**Application Reference:** 2026/0049.

**Location:** 9 Duke Street, Hoyland, Barnsley, S74 9QS.

This application seeks planning permission for the erection of a detached double garage.

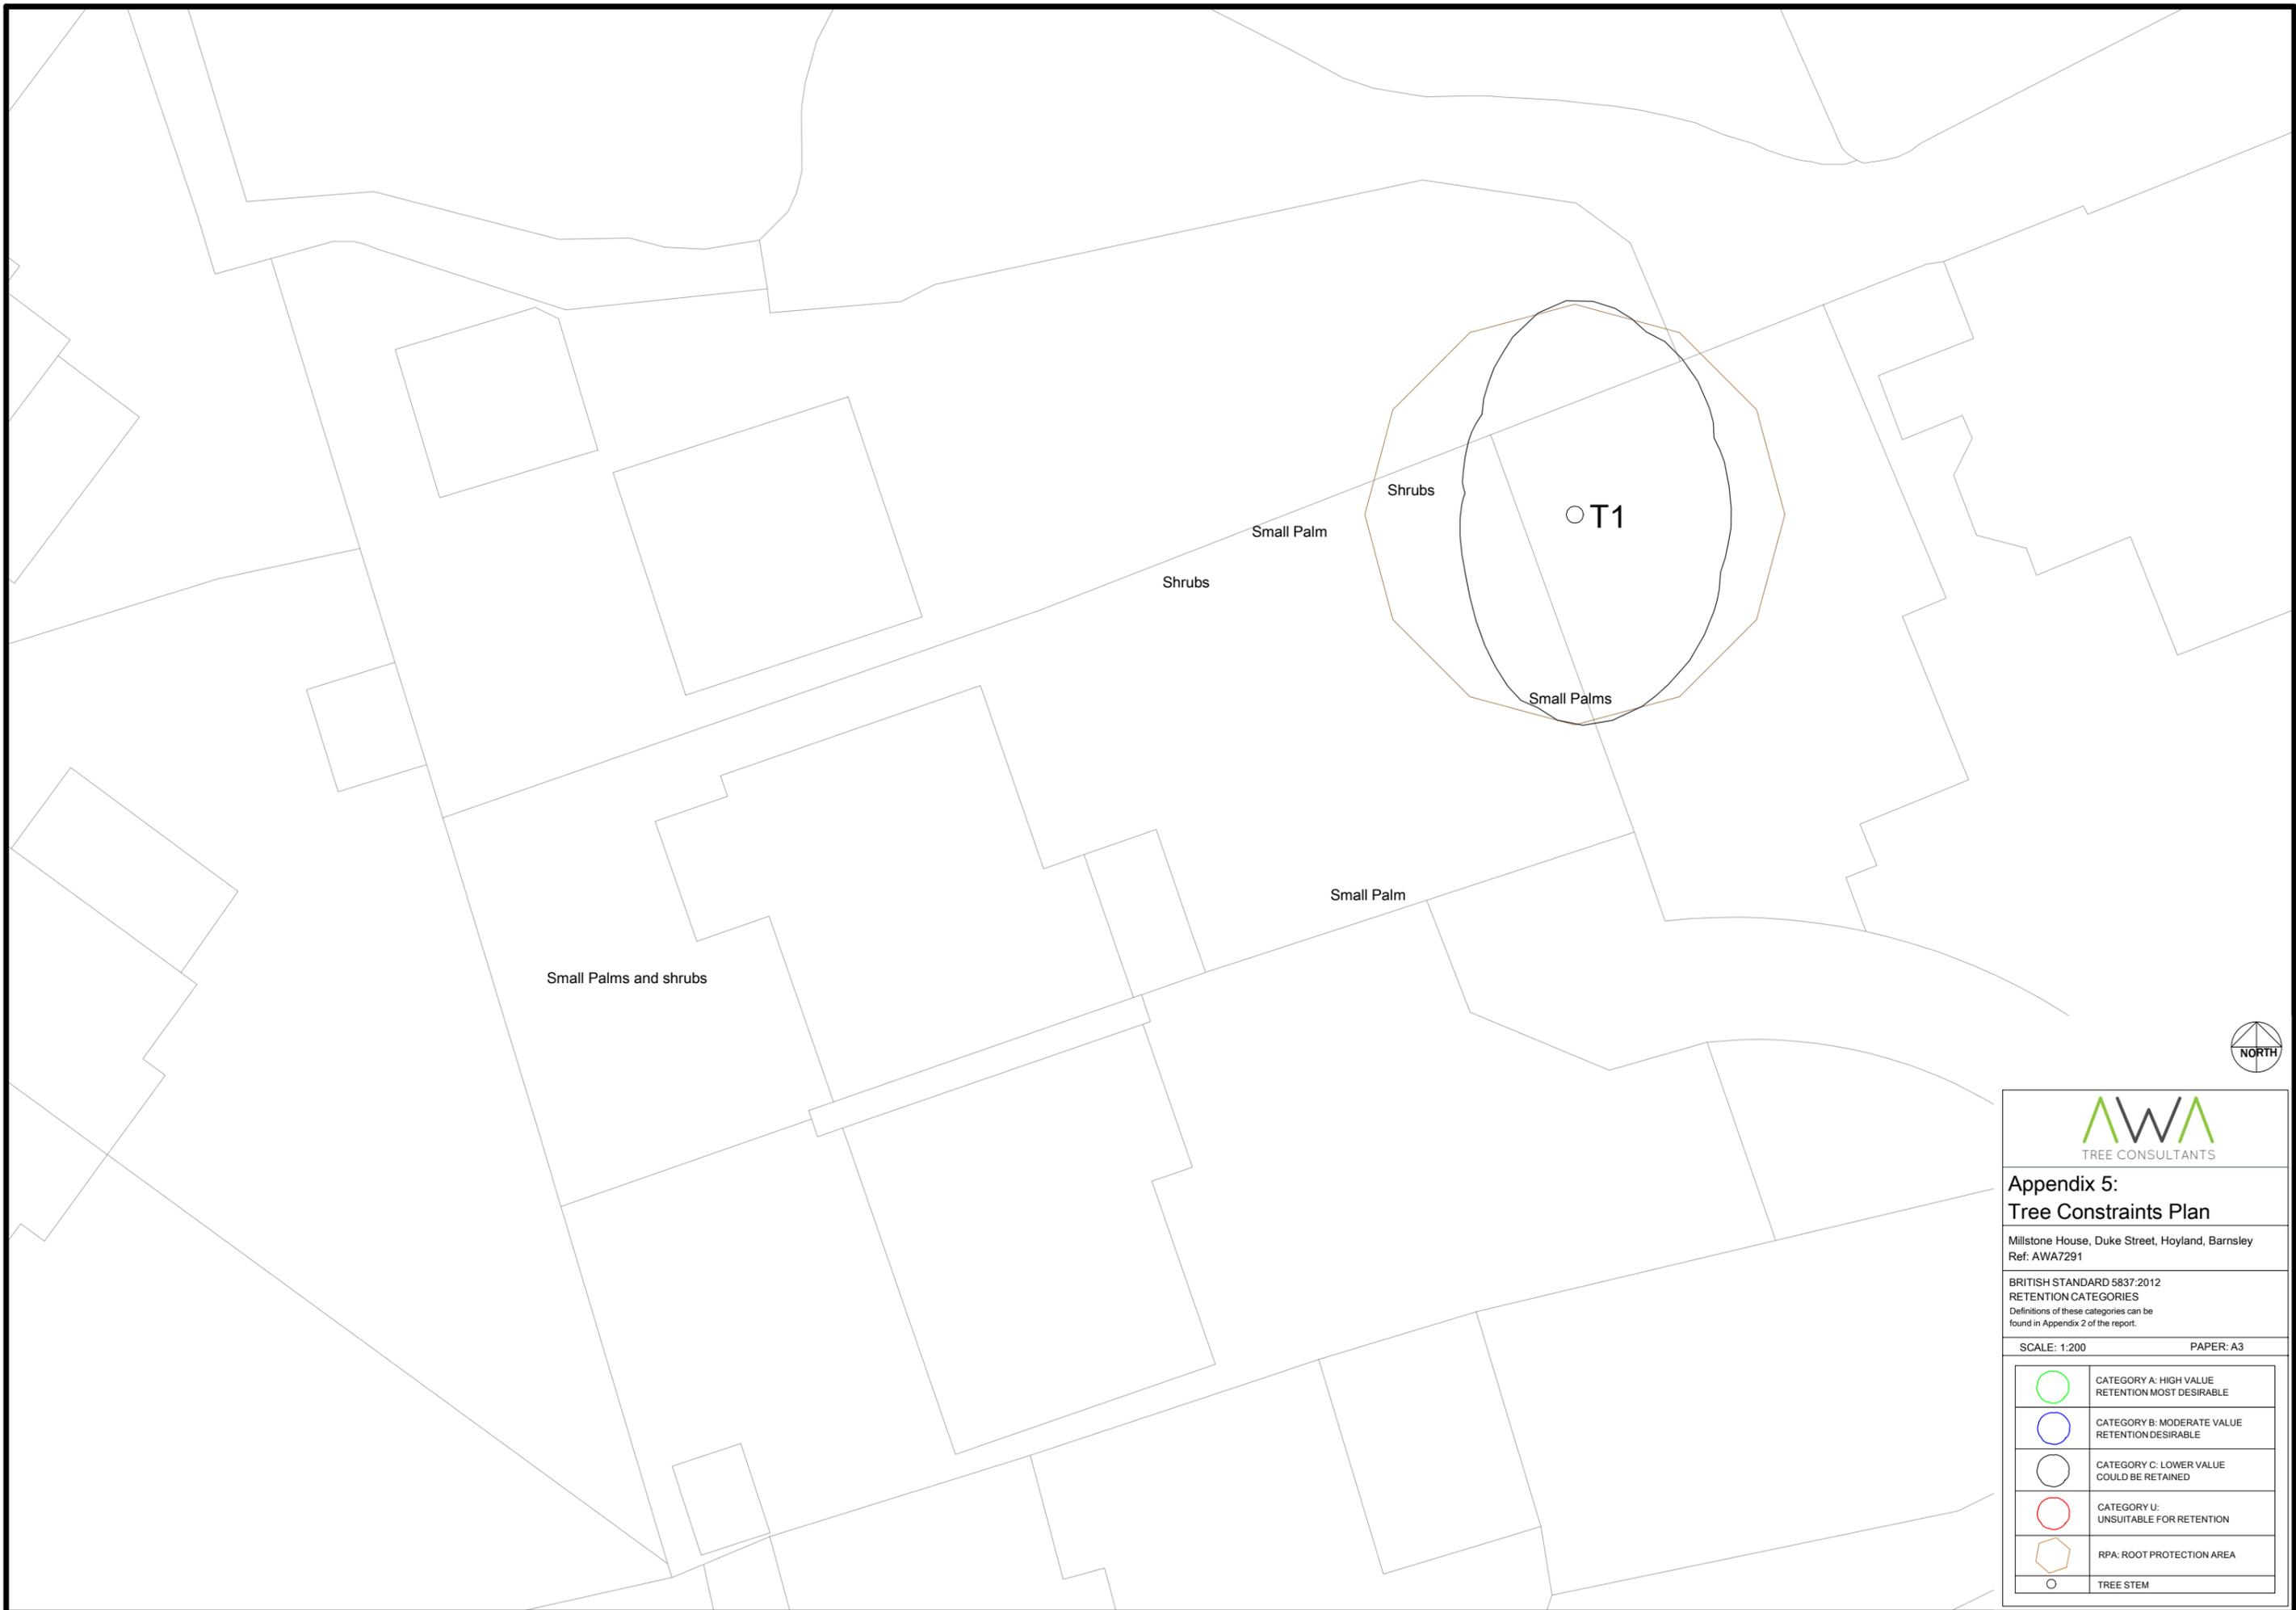
While the proposed garage would be erected in proximity of this protected off-site Ash tree, the area is currently hard surfaced, and the tree is located behind a stone boundary wall and at a lower level than the development site. As such, despite works being shown in the measured root protection area (RPA) it is unlikely that there would be any significant root activity within the site. This coupled with the shallow foundations proposed mean the tree should remain unaffected. Likewise, the canopy of the tree is quite high over the site and as such, mechanical damage should not be an issue. As such the existing boundary wall should act as sufficient protection for the tree during the works.

Project	Detached Double Garage	
Client	Mr & Mrs David Howarth	
Title	Elevations as Proposed	
Address	9 Duke Street, Hoyland, Barnsley. S74 9QS	
Drawn By	GGG	
Scale	1:100 @ A4	Date Jan 26
Drawing No	949-05	Rev A

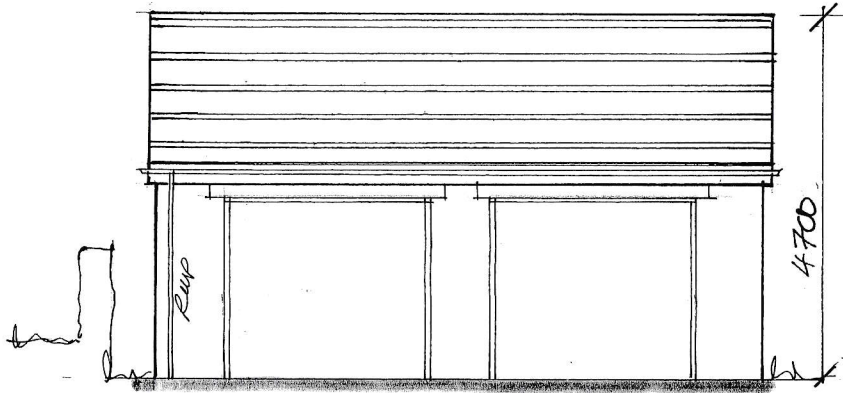
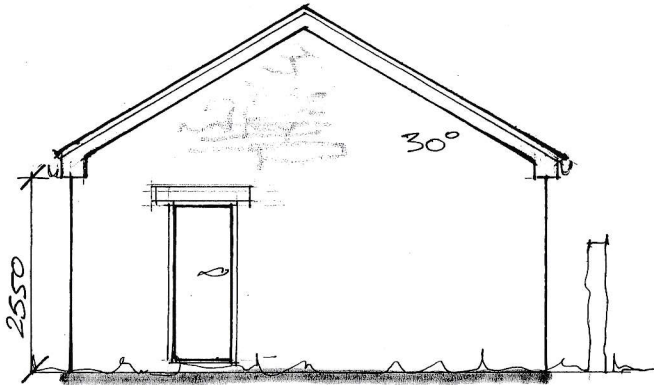
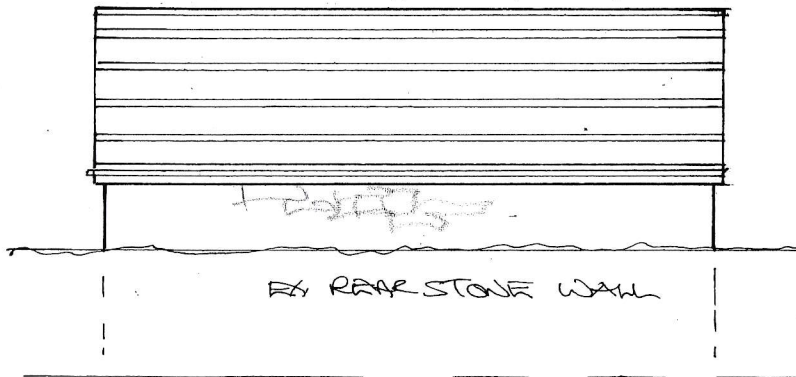
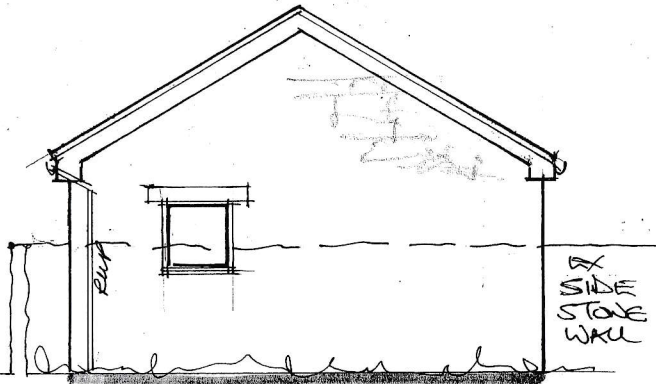
During the application process, the proposal was amended to reduce the pitch and height of the roof of the proposed garage.

- The ridge height creating a top-heavy structure that is excessive and overbearing.
- Impact regarding overshadowing.
- Impact regarding outlook.

In this instance, the proposed garage would be located to the front of the application dwellinghouse between the dwellinghouse and the private access road off Duke Street. The proposed garage would also adopt an eaves and ridge height that would exceed the limits established by the SPD.

- *Amendments to reduce the pitch and height of the roof of the proposed garage.*

949-05 Rev. A Elevations as Proposed received 9<sup>th</sup> April 2026.

Title: Layout as Proposed

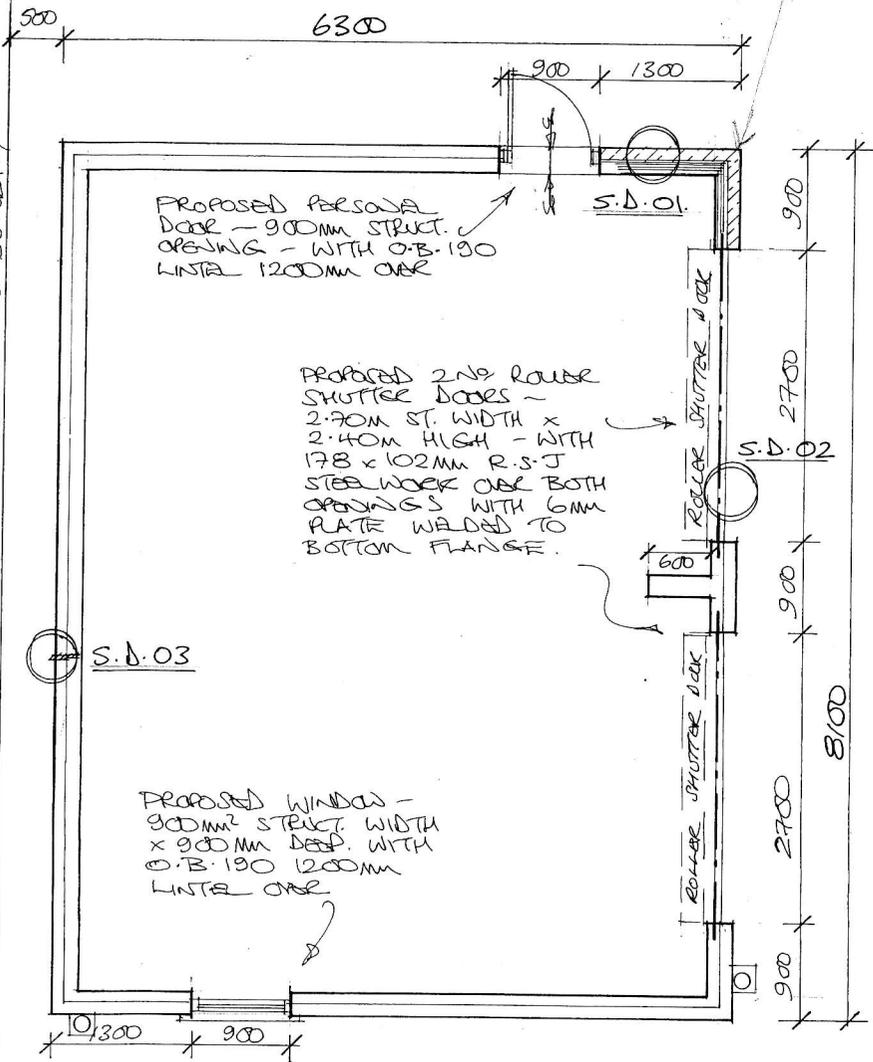
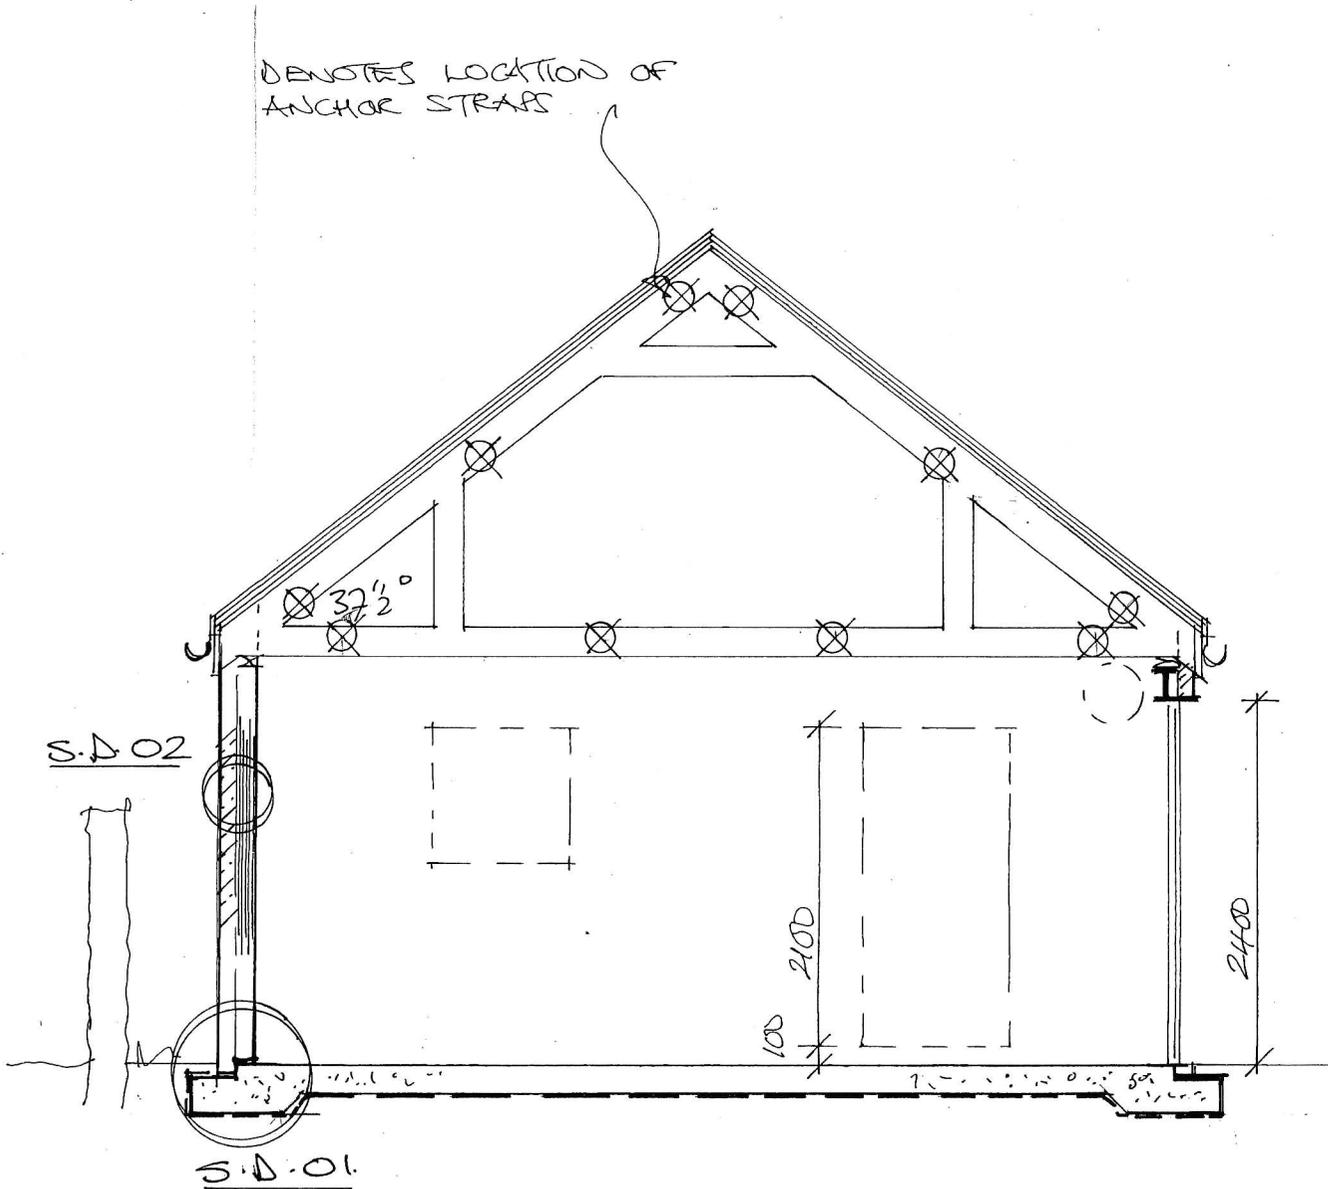
The comment received does not raise any objections the proposal but states that the proposed site plan and proposed ground floor plan do not correspond. The plans have been checked, and the local planning authority is satisfied that the plans are correct.
